Your Ref
LU/379/18/RES
Our Ref
PLAN-026453
Date
14/02/2019

Proposal: Approval of reserved matters following outline consent LU/47/11/ for 50 No. dwellings. This application may affect the setting of a listed building.
Site: Parcel A2/B6 Hampton Park Toddington Lane Littlehampton BN17 7PL.
LU/379/18/RES

A	23/11/18	Revised to incorporate layout changes and Highway comments.	AJW
REV. No.	DATE	DESCRIPTION	INITIALS
Client	Persimmon Homes (Thames Valley)		
Project	Phase 3 Littlehampton		
Title	Drainage Plan		
Scale	1:250 @ A0	Date	June 2018
Checked	KTG	Drawn	AJW
Drawing No.	5825:01		
Rev	A

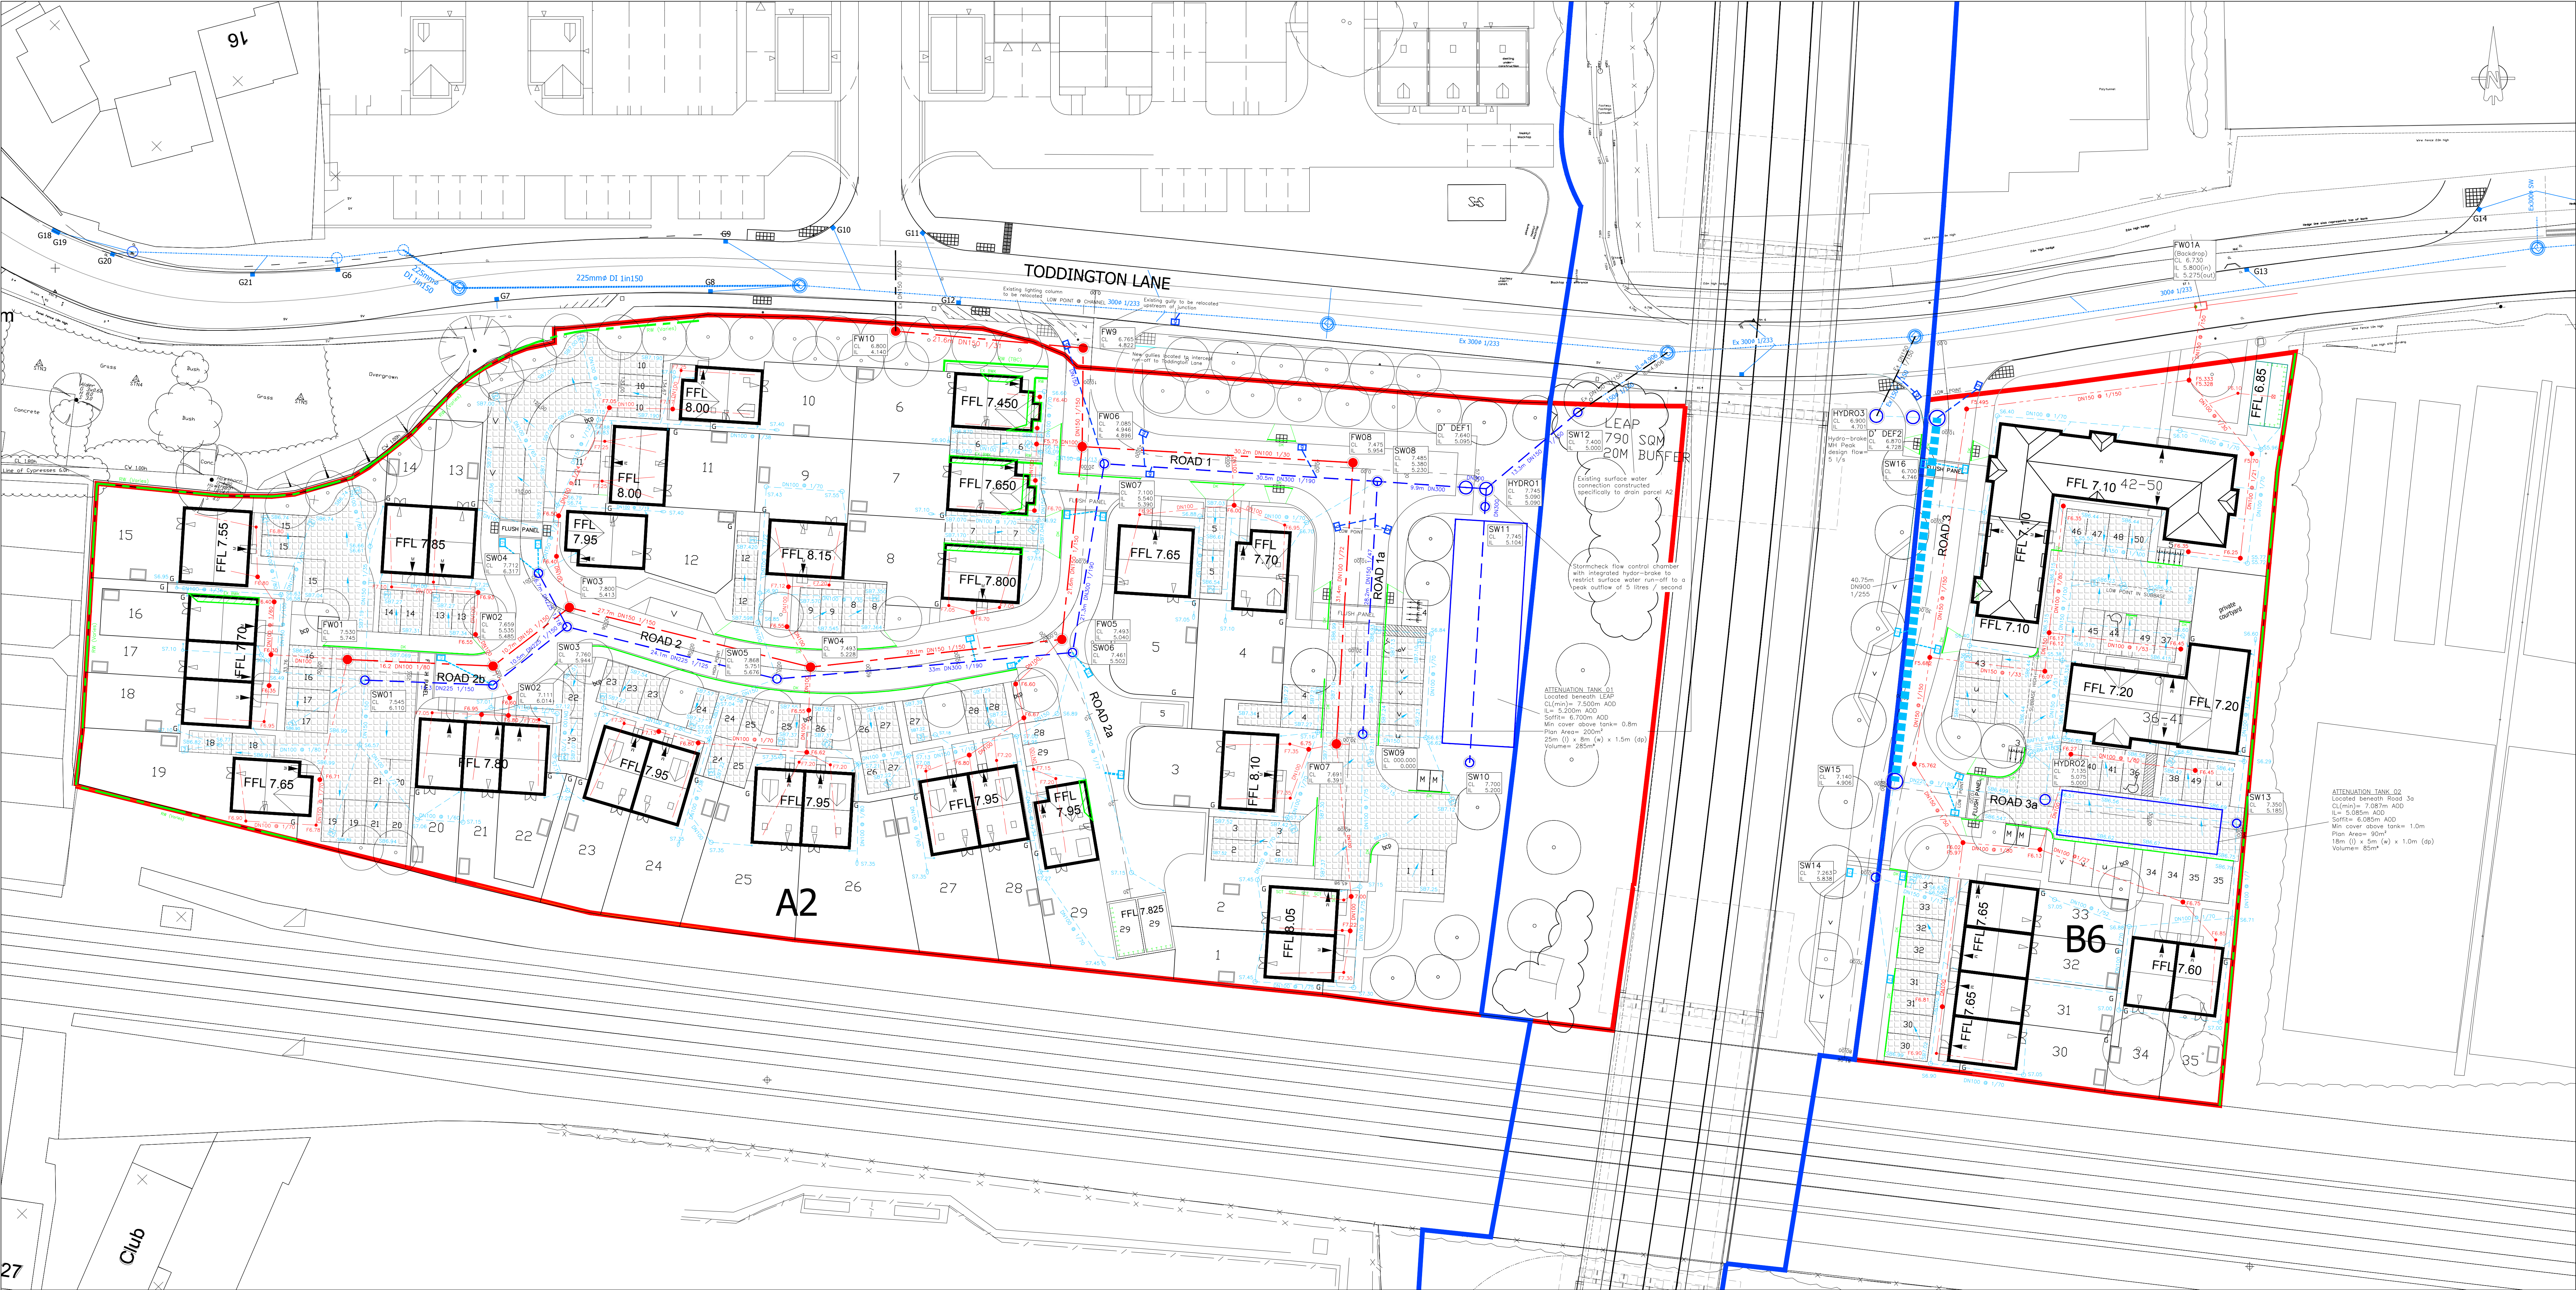
Southern Water would not recommend approval of layout, until the applicant demonstrates that the standoff distance for public foul rising main is to be maintained. Also due to the vibration, noise and potential odour generated by sewage pumping stations, no habitable rooms should be located closer than 15 metres from foul sewerage pumping station site.

or land drainage is to enter public sewers. The design of adoptable drainage shall take into account that no tanked permeable paving or permeable paving acting as soakaway will be allowed to be constructed over or within 5 m of adoptable sewers.
